**PLAN REVIEW SHEET**

**Petition #: 2024-089**

SHEET NUMBER
RZ-2

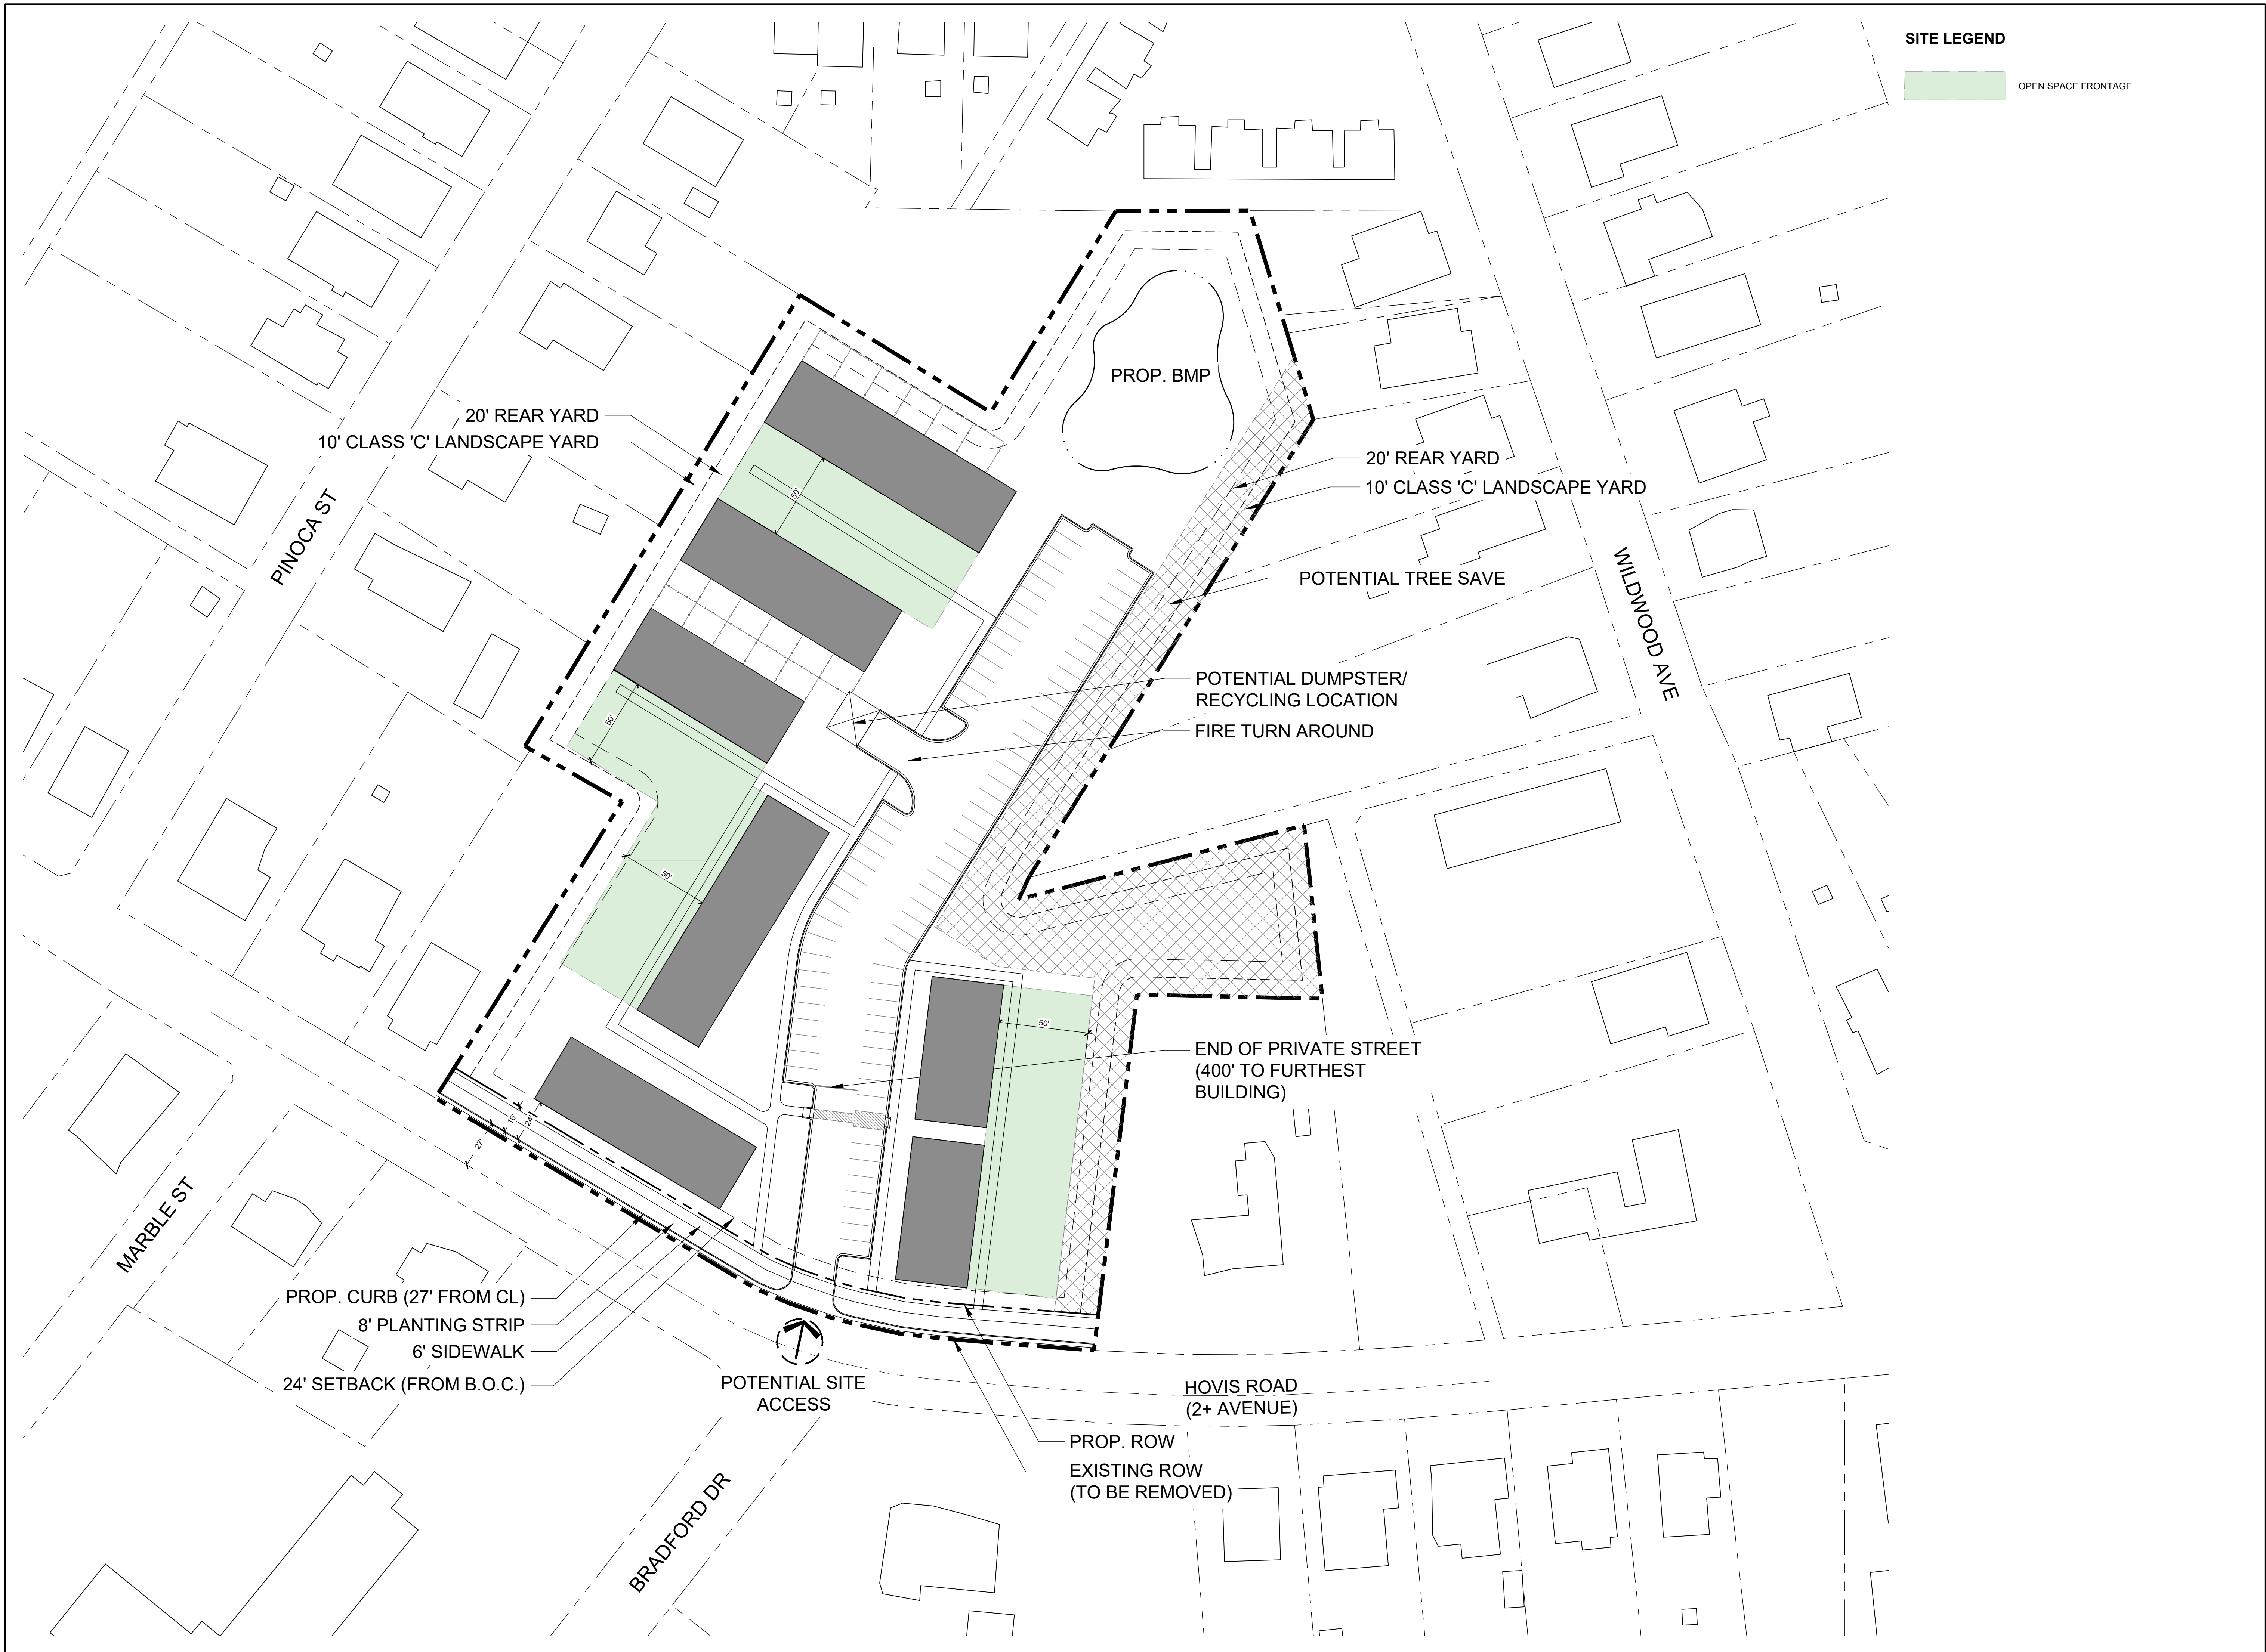
The Site is located along Hovis Rd and is served by CATS bus route #18. CATS requires the upgrade of the existing bus stop to an ADA-compliant bus detail 60.02A. The final location will be coordinated with the developer during the Land Development plan review process.
